**WELWYN HATFIELD BOROUGH COUNCIL
EXECUTIVE DIRECTOR - PLANNING, PUBLIC PROTECTION AND GOVERNANCE**

DELEGATED APPLICATION

Application No: 6/2018/1956/FULL
Location: Stanborough School Lemsford Lane Welwyn Garden City AL8 6YR
Proposal: Erection of new teaching block, replacement tarmac play areas and additional parking provision
Officer: Ms Louise Sahlke

Recommendation: Granted

client
Governors of Stanborough School
 building + drawing title
Existing & Proposed Layout Car Park Site

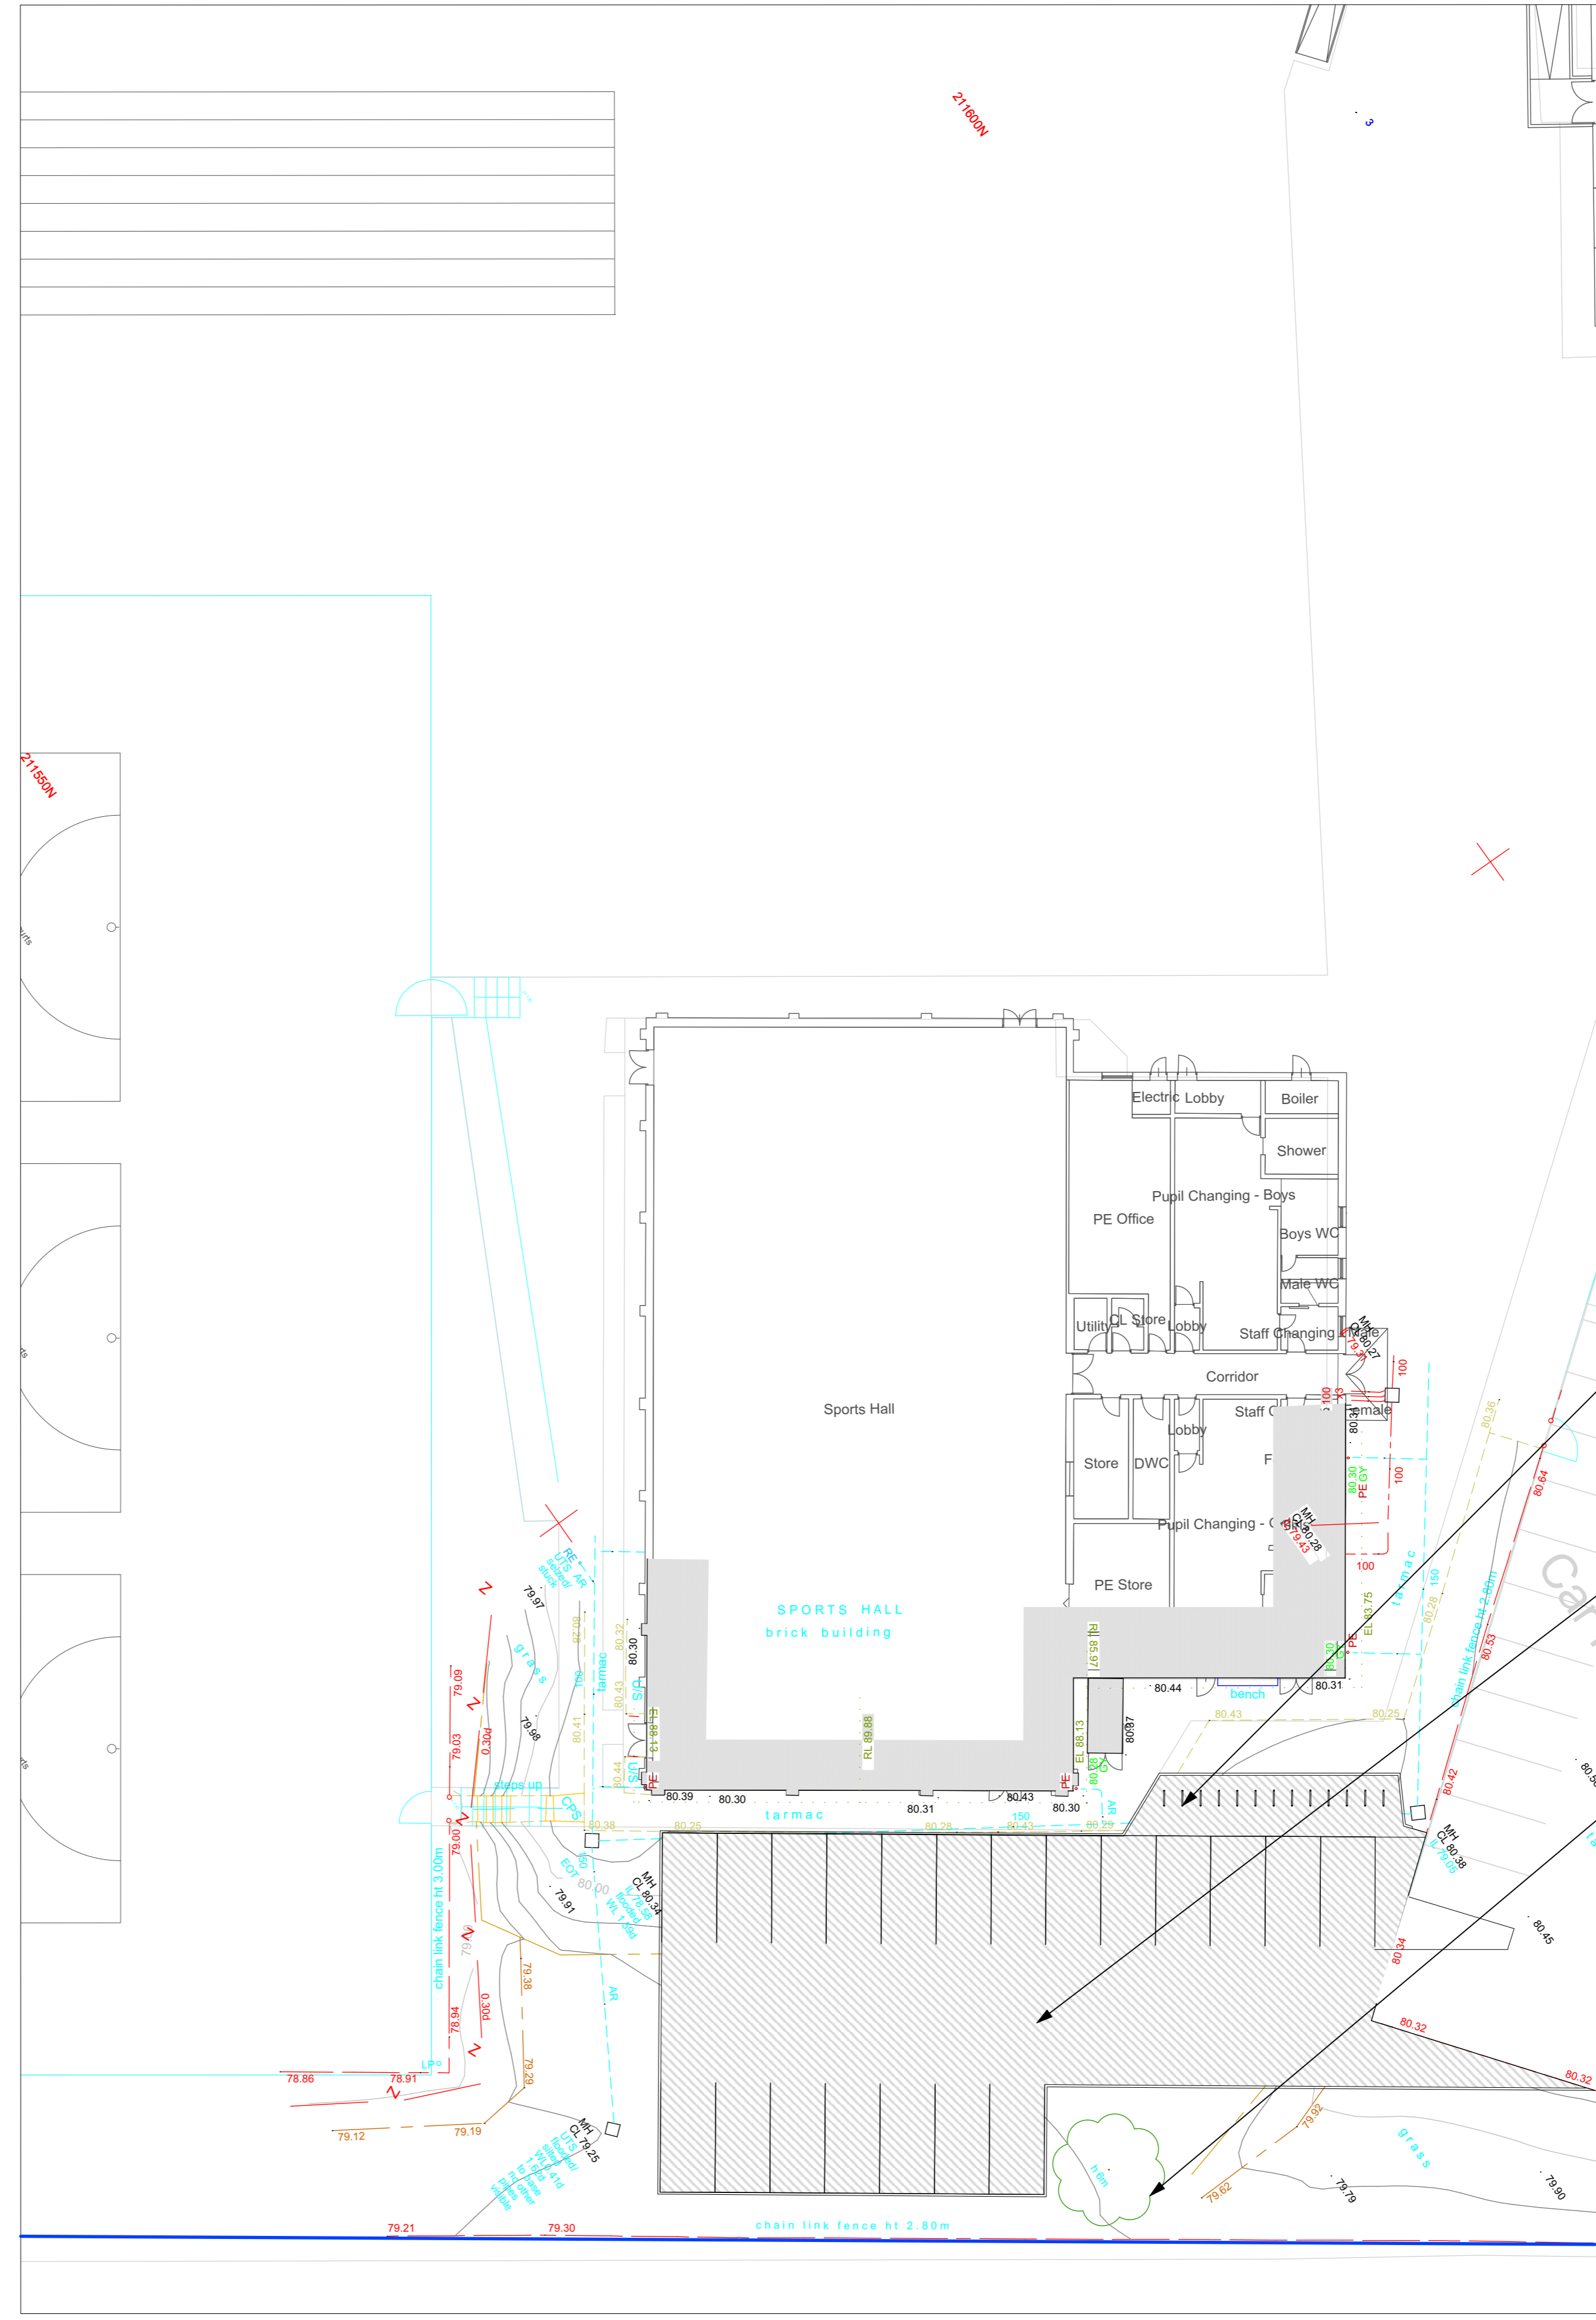
The site has car parking for 130 spaces (staff). Development proposals increase this by 35 car parking spaces. The site also provides 1 space for blue badge owners, and increases this to 3.

The 35 spaces provided represents 83% on the maximum permissible. It is necessary to observe that the 42 spaces provides for standards against the additional school size, but ignores the potential parking requirement for the school at it's permitted scale. The TA identifies that to provide for the fall back situation as well as the development scenario considered would require a maximum number of new spaces of 59, of which the actual proposals would represent 60%. Therefore it is acknowledged that there a shortfall in car parking provision.

The new car parking is located by way of entry through the netball court / car park overflow and observed that the provision of the additional car parking shall further prejudice the likelihood of their availability as sports facilities in the future, noting the potential vehicle access requirement.

Limited information has been provided in regards to cycle parking. There will be a policy requirement for a further 26 cycle parking spaces to be provided. The proposals provide this (drawing 2155 03 0100) by way of Sheffield stands within the new car parking area. No detail is provided whether cycle facilities would be covered or secured. Cycle stores would benefit from alternate location to make them more prominent, thereby promoting their use as well as increasing natural surveillance and improving security.

6. Prior to the first occupation of the development a revised scheme for the parking of cycles has been submitted to and approved in writing by the Local Planning Authority. The approved scheme shall be fully implemented before the development is first occupied or brought into use and thereafter retained for this purpose.
